Your ref: SSD-23480429
Our ref: DOC25/272747

Subject: Request for advice on additional information - Westgate Kemps Creek (SSD-23480429) Mamre Road Precinct

Attachment A – CPHR advice on additional information - Westgate Kemps Creek (SSD-23480429)

Figure 10: Stormwater Staging

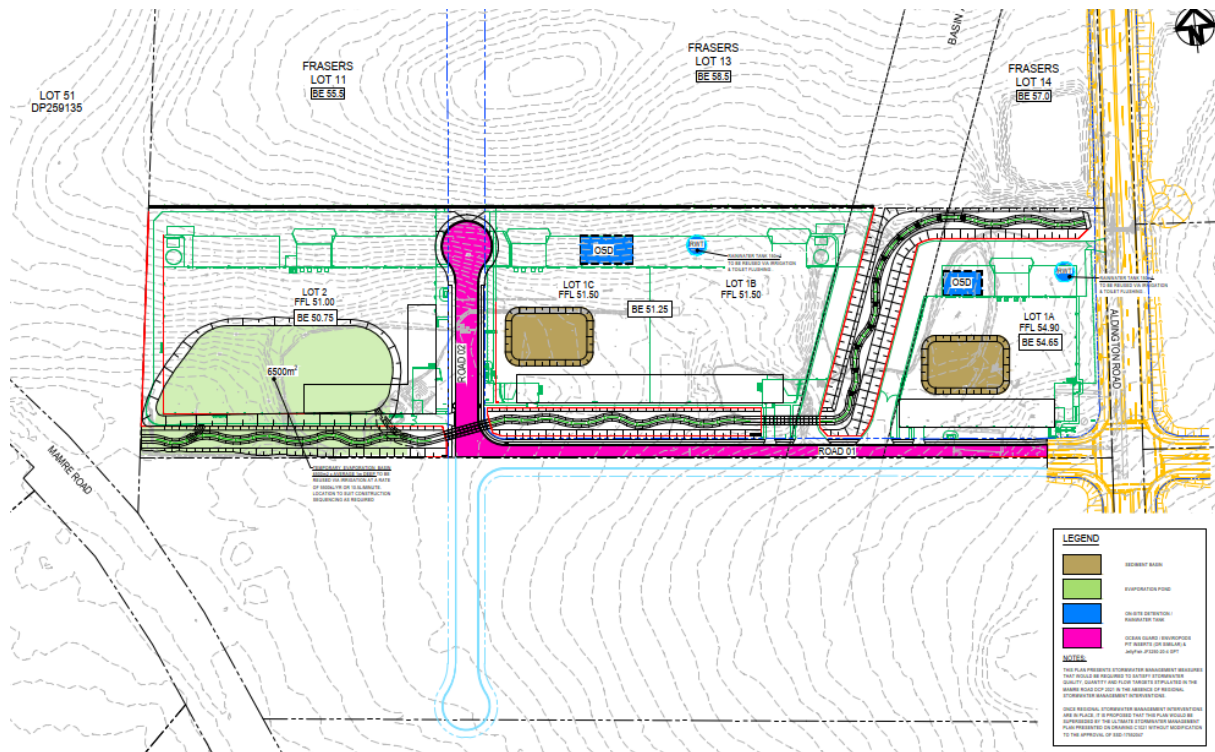
- Figure 5 (i.e. civil drawing C250) – Interim Arrangement in the WSMP shows sediment basins used on all lots and OSD tanks used on lots 1A, 1B and 1C. This is not reflected in the MUSIC model.
- The MUSIC model uses two GPT's (one for Lot 1A and one for Lot 1B). Figure 5 refers to GPT's but does not show where they are located in the design.
- Permanent pool depth used in the MUSIC model is 7,950 m³, whereas Figure 5 shows surface area of 5,300 m² with a depth of 1m (so absolute maximum permanent pool depth could be 5,300 m³). It is unclear where the 7,950 m³ has come from.

Prior to determination, ensure the MUSIC model, WSMP and civil drawings all align.
